Recommendation Report for Planning Permission for Works or Extension to a Dwelling

REF NO: AW/272/25/HH

LOCATION: 213 Aldwick Road
Aldwick
PO21 3QG

PROPOSAL: Single storey rear extension.

Project Proposed plans	Sheet 2
Date 7th November 2025	
Scale 1 : 50 & 1 : 100

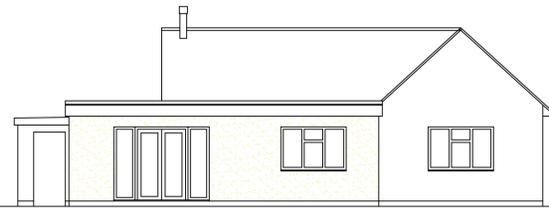
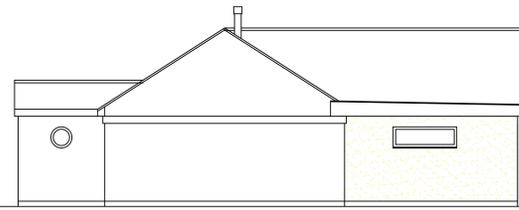
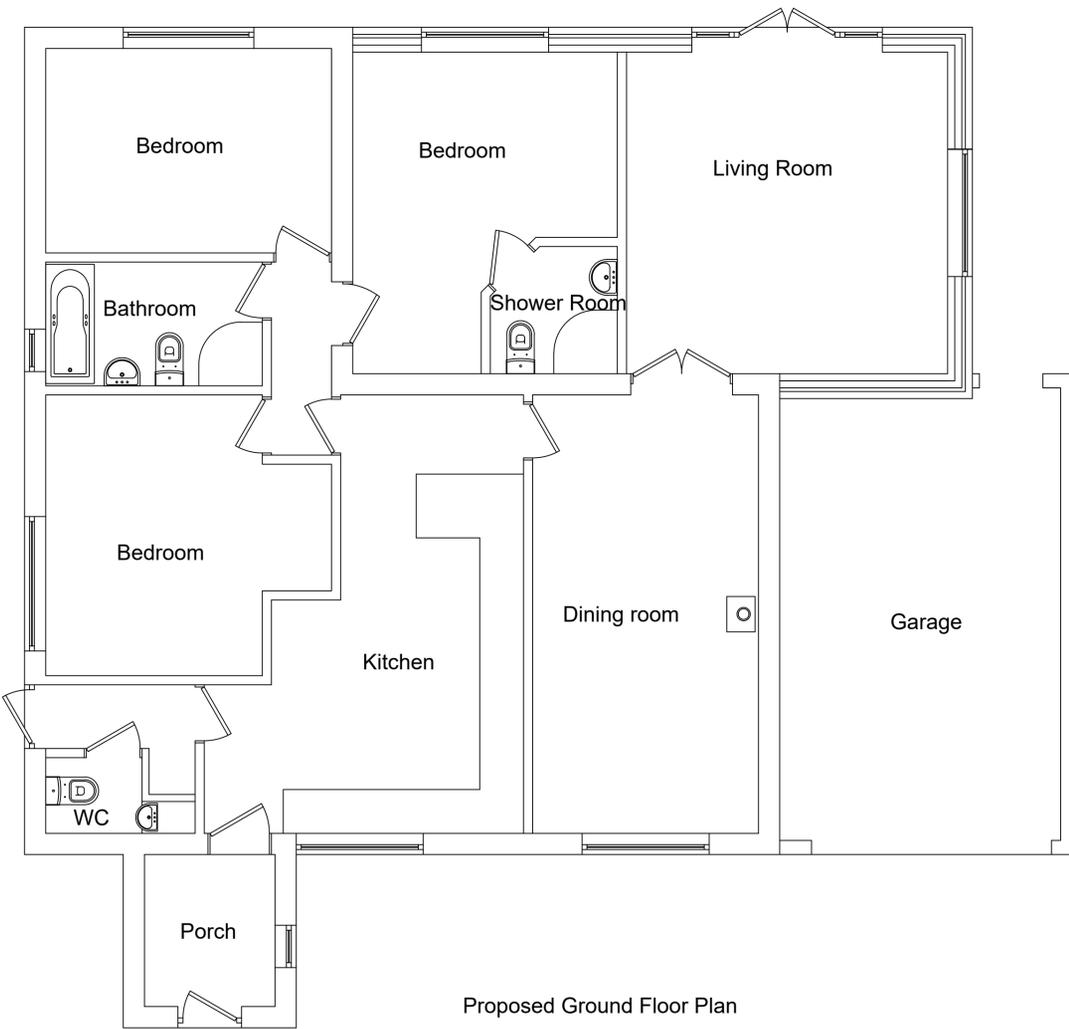
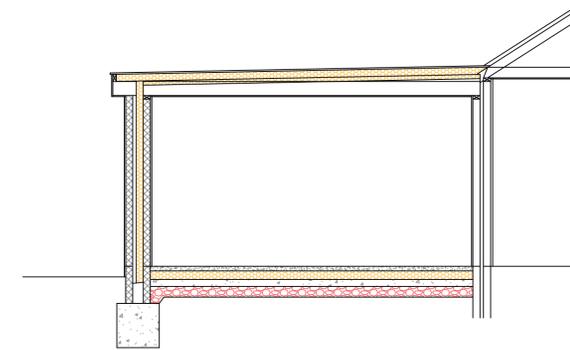
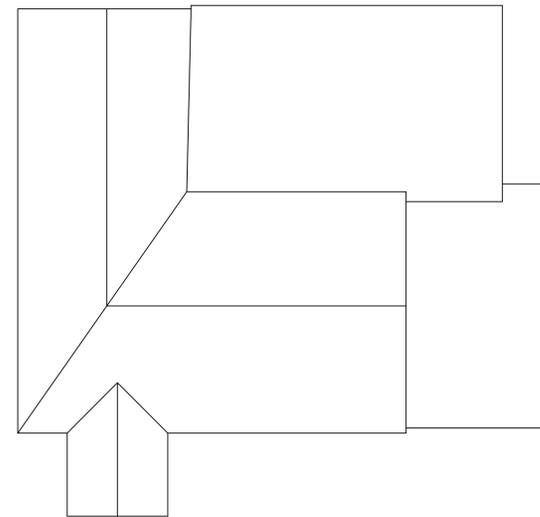
The proposed extension would infill the area between the existing rear projection and the main rear elevation of the dwelling. It would measure approximately 5m in depth and span almost the full width of the dwelling, including the garage, resulting in an overall width of approximately 8.8m.

The extension would have a flat roof form with a maximum height of approximately 3m. This would be marginally higher than the existing garage, which measures approximately 2.5m in height, and would result in a limited degree of visibility within the street scene. However, given that the dwelling is set back from the highway, the proposal would not result in any harm to the character or appearance of the surrounding area. The external walls would be finished in painted render to match the existing dwelling, thereby ensuring visual integration with the host property.

Fenestration to the rear (south) elevation would include a patio door with vertical window panels either side, together with a three-pane window. The side elevation (west) would feature a horizontal window, and a door is proposed to provide access from the garage to the rear garden. These elements would be consistent with the existing dwelling and would be acceptable in terms of design and appearance.

The proposed depth of the rear extension would not comply with the guidance set out in the Arun Design Guide (ADG), which states that single storey rear extensions should not exceed 3.3m in depth. However, the proposed depth would align with the existing rear projection, and similar rear extensions are present on neighbouring properties. In this context, the proposal would not appear visually intrusive or out of character, and the departure from the ADG is acceptable in this instance.

The proposed rear extension would be set in approximately 2m from the western side boundary, maintaining a suitable separation distance from neighbouring dwelling to the west. The nearest neighbouring property to the south is located at a distance of approximately 12.5m from the extension, ensuring an appropriate level of separation would be retained. The eastern side boundary faces a highway, and as such would not have any residential impact to the east. The proposed extension would not result in overbearing or overshadowing impacts to any neighbouring dwellings.

A window is proposed within the western side elevation at ground floor level. Given its orientation and the separation distance to the neighbouring property, this window would not give rise to any loss of privacy or overlooking. The fenestration within the rear elevation of the extension would have an outlook of the rear garden serving the host dwelling, and would not result in overlooking.

The proposed extension would result in a remaining rear garden depth of approximately 9.5m. This would be below the 10.5m recommended within the ADG for garden amenity space. However, the extension would project in line with the existing rear projection, and this loss of residential amenity would be comparable to the existing situation and is therefore acceptable.
